**From:** Arun District Council Leisure & Greenspace

**Date:** 27/11/2024

## **Application ref: F/14/24/RES, F/15/24/RES, F/16/24/RES**

**Location:** Land at Ford Airfield Ford

**KEY PLAN**

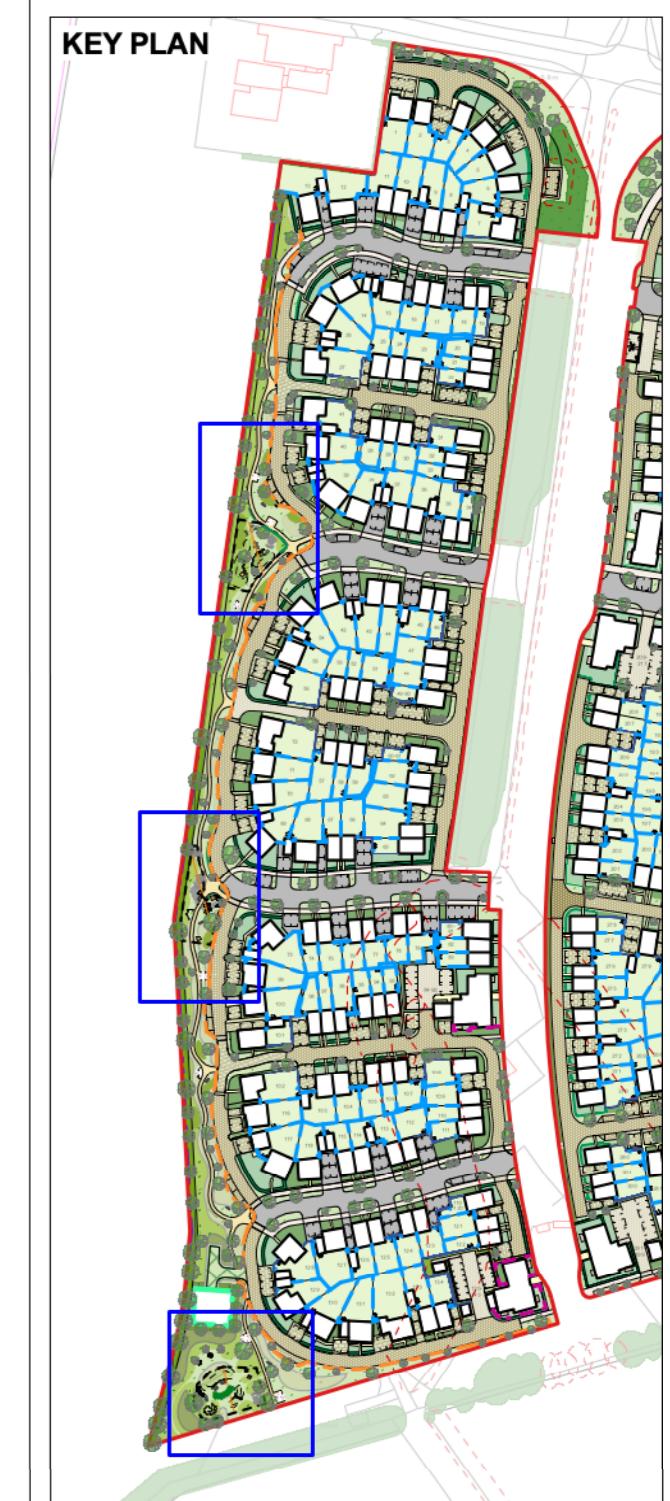
Areas where LAPs and fitness trails have been provided. The 3 LAPs would deliver 1,200sqm of LAP, however it is unclear how 300sqm of fitness trail will be accommodated in accordance with the Design Code. The locations of the LAPs provide sufficient buffer distances to frontages of dwellings and is acceptable.

The LAP play areas submitted indicatively (Shown on plan reference RM1-XX-DR-L-P-025) show a general commitment to align the play items with the approved play themes within the Ford Design Code. However, there is a lot of space between items and items which are repetitive (multiple animal statues) and therefore I would wish to see some changes made. However, it is not proposed to approve these as part of the reserved matters application. However, the key does not specify that play will be submitted later, as the other RMs do, and this should be made clear, as the LPA will wish to approve these at a later date through planning condition. The Case officer should ensure that these areas are conditioned for approval at a later stage, and that all submissions must accord with the Design Code to deliver high quality, bespoke, and inclusive play in line with the proposed themes agreed.

Figure 6.1. RM1 - proposed St Mary's Meadow western edge landscape buffer

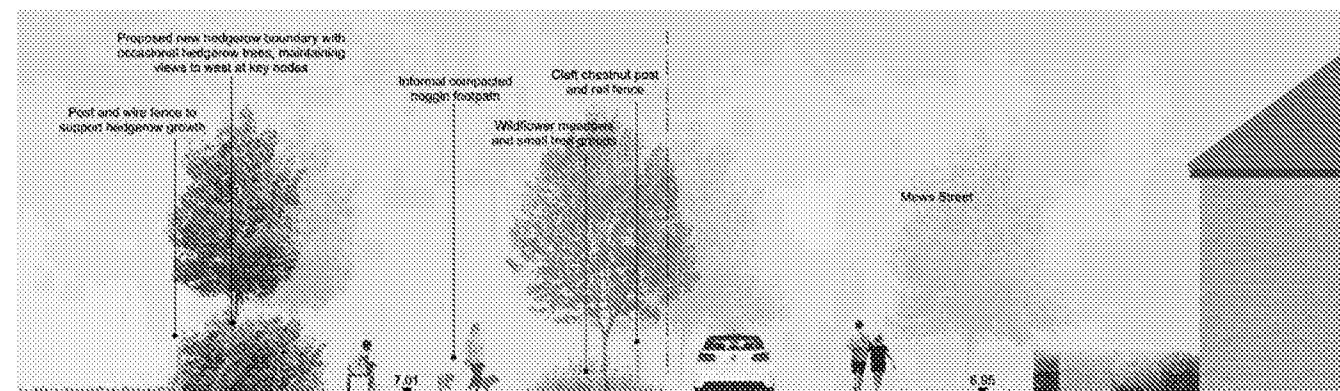
The new western boundary of this RM will create a new frontage onto the open countryside and interface with views from the Yapton Conservation Area. Therefore, trees should be planted larger than extra heavy standard size (semi mature and mature) to provide a good quality buffer. The number of trees also appear insufficient (as only 38no are shown across this extensive edge) to provide a strong structural boundary with sufficient height.
